From: Anita Gardner
Sent: 28 May 2019 09:51
To: Planning.Responses
Subject: FW: Planning Application: A/9/19/PL : Pound Place 4 of 4
Attachments: image001.png; ATT00001.htm; 1388_ Planning Drawing Issue Sheet.pdf; ATT00002.htm; 1388_004B Bin Store Plan and Elevations.pdf; ATT00003.htm

Drawing 1388/001J – Site Layout General Arrangement

Drawing 1388/004B – Bin Store

Client	Hallmark Care Homes		
Project	Proposed Care Home Pound Place Roundstone Lane Angmering		
Drawing	Proposed Elevations at 1:200		
Date	March 2018	Scale	1:200 @ A1
Drawn by	RAC	Drawing No	1388/201
Checked by	.		E
Status	Preliminary

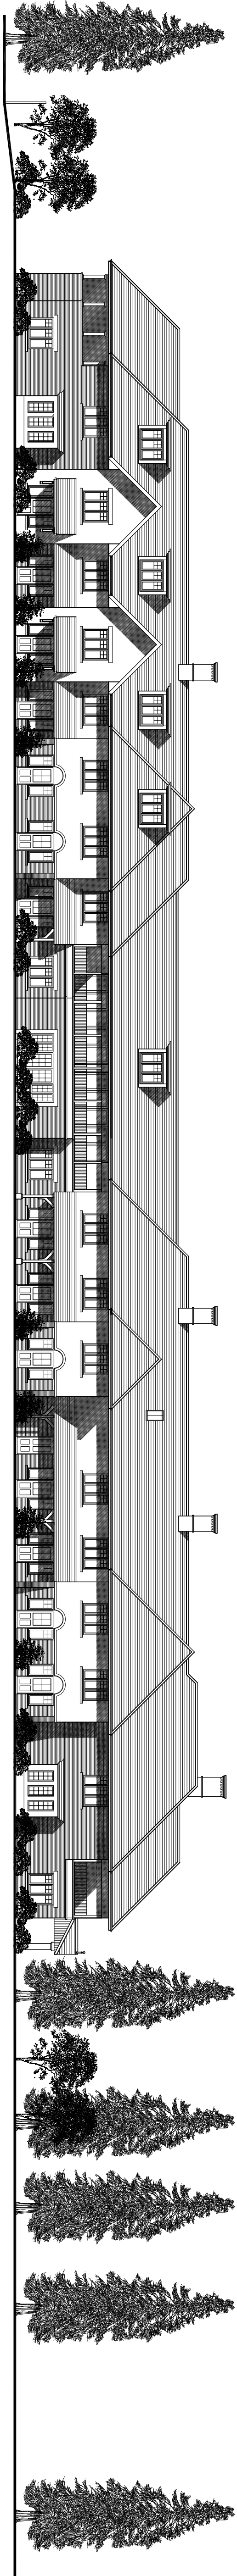
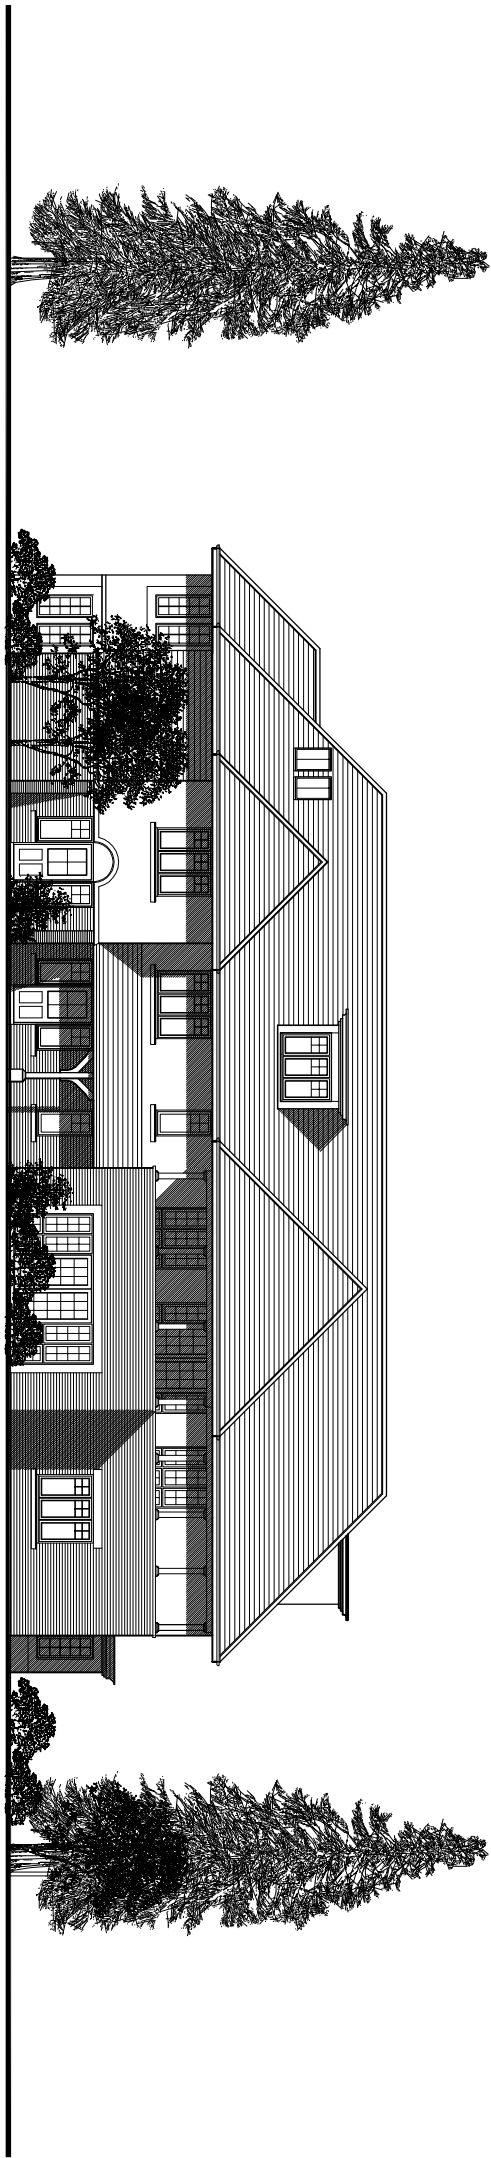
Amendments to dormer window locations to North and East Elevations – number of dormers to North Elevation reduced by two and these have been relocated - one to the East Elevation and the other to the west facing return.

Dormer windows- The number of dormer windows has not been reduced overall. Rather, two dormers have been removed from the North Elevation and then relocated one to the East Elevation and the other to the west facing return.

Client		Hallmark Care Homes	
Project		Proposed Care Home Pound Place Roundstone Lane Angmering	
Drawing		External Bin Store Plan & Elevations	
Date	March 2018	Scale	1:50 @ A2
Drawn by	RAC	Drawing No	1388/004
Checked by	-	Status	B

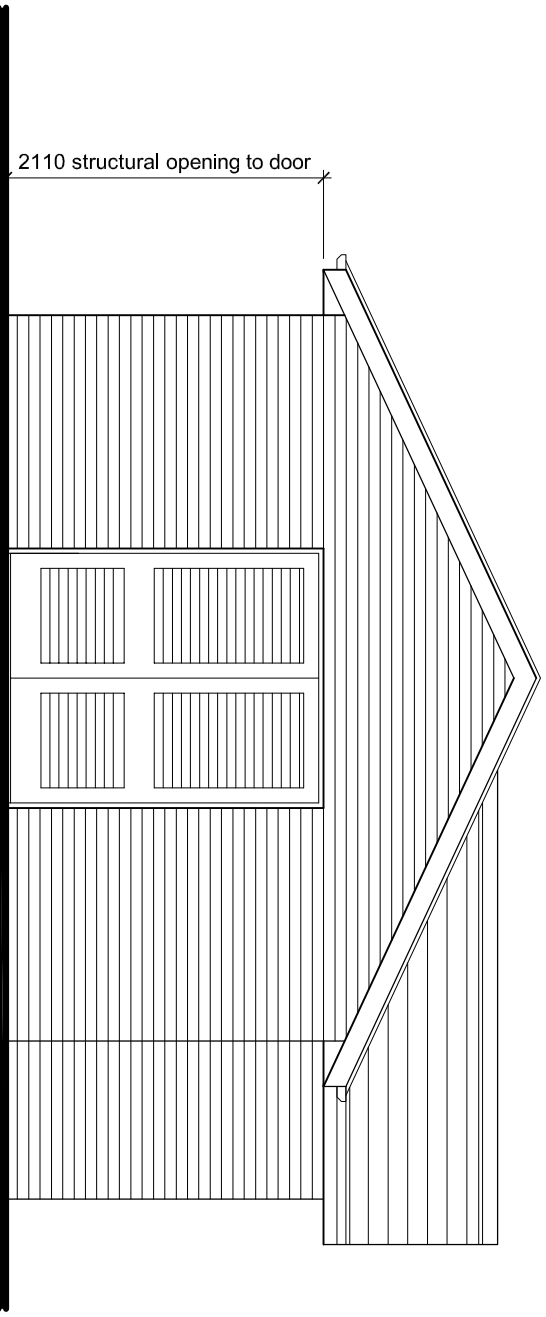
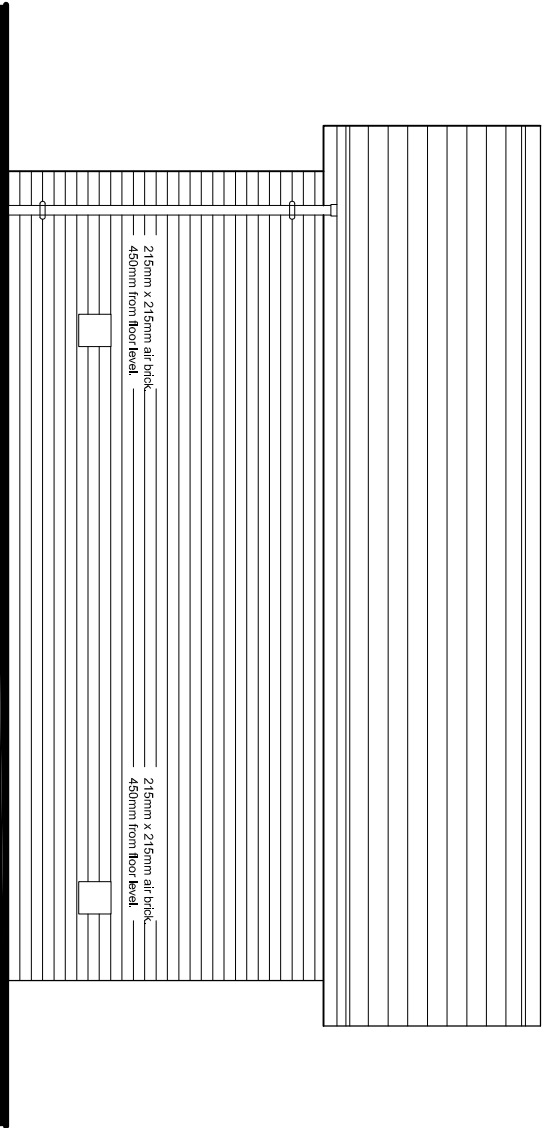
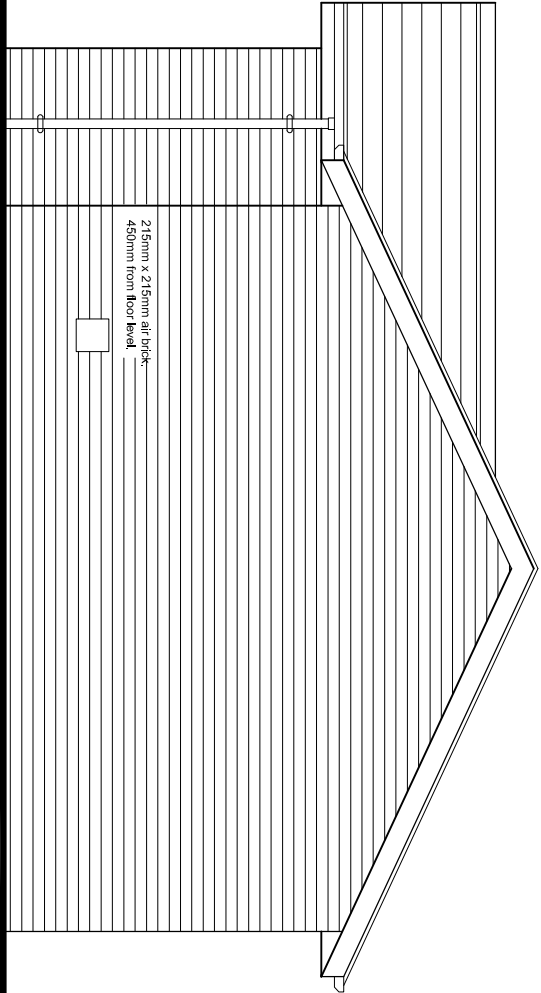
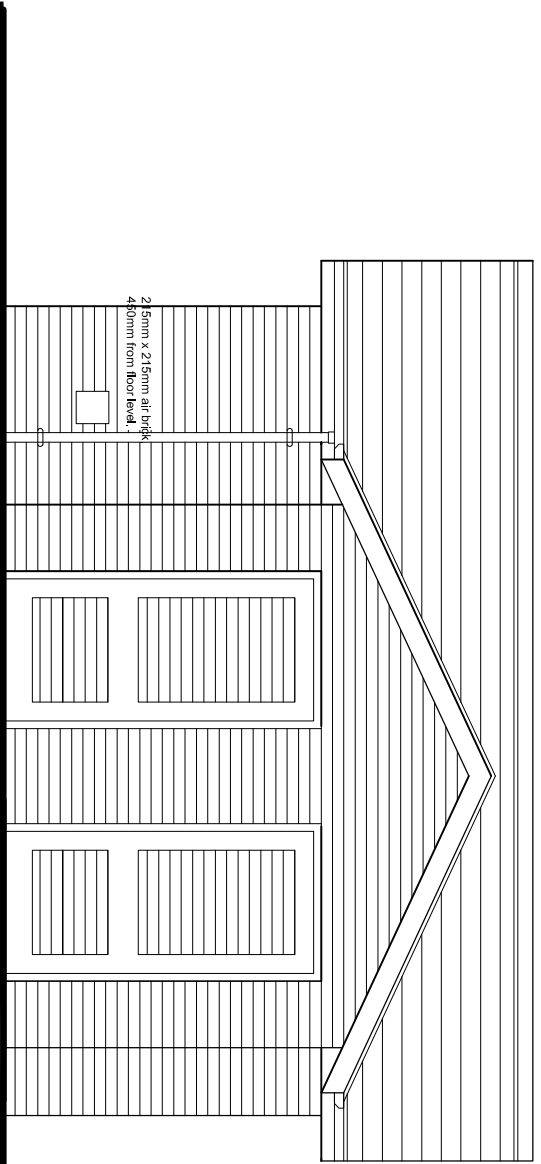
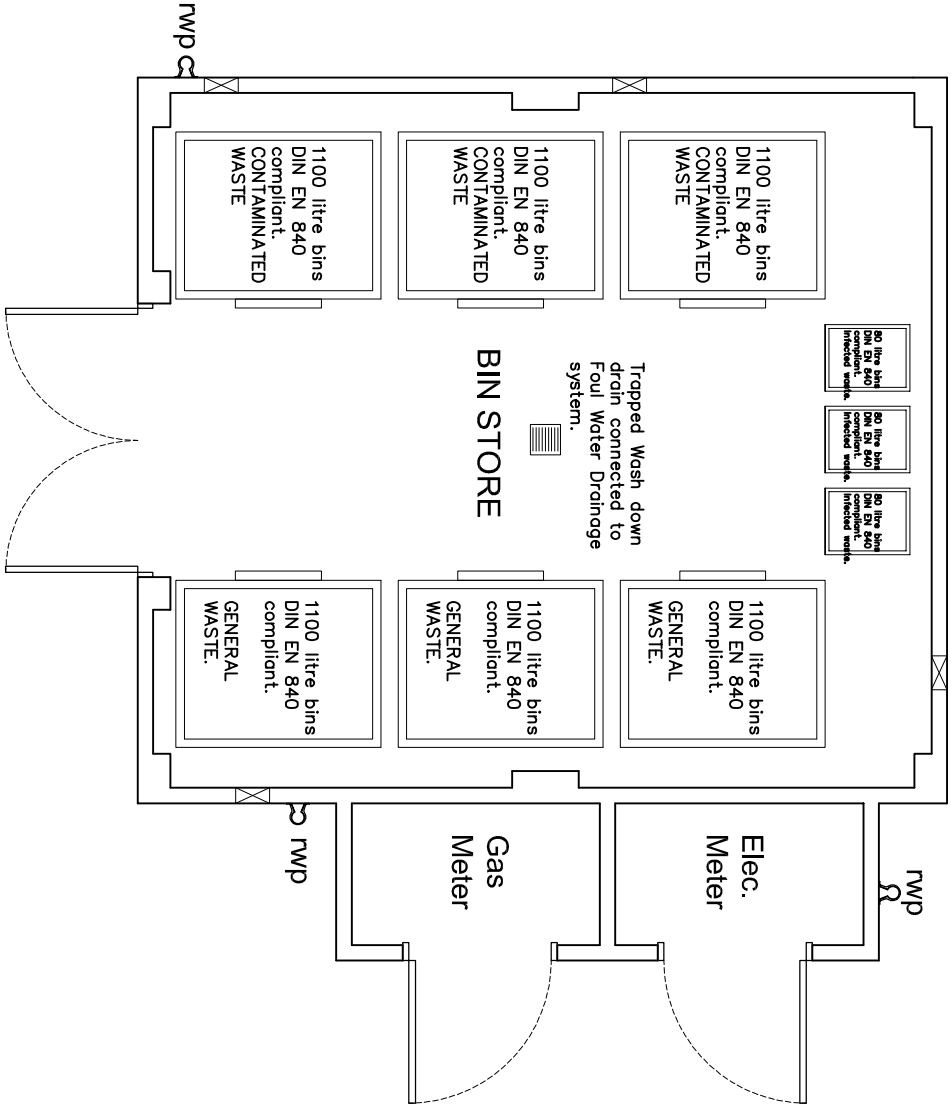
Building rotated to match site layout.
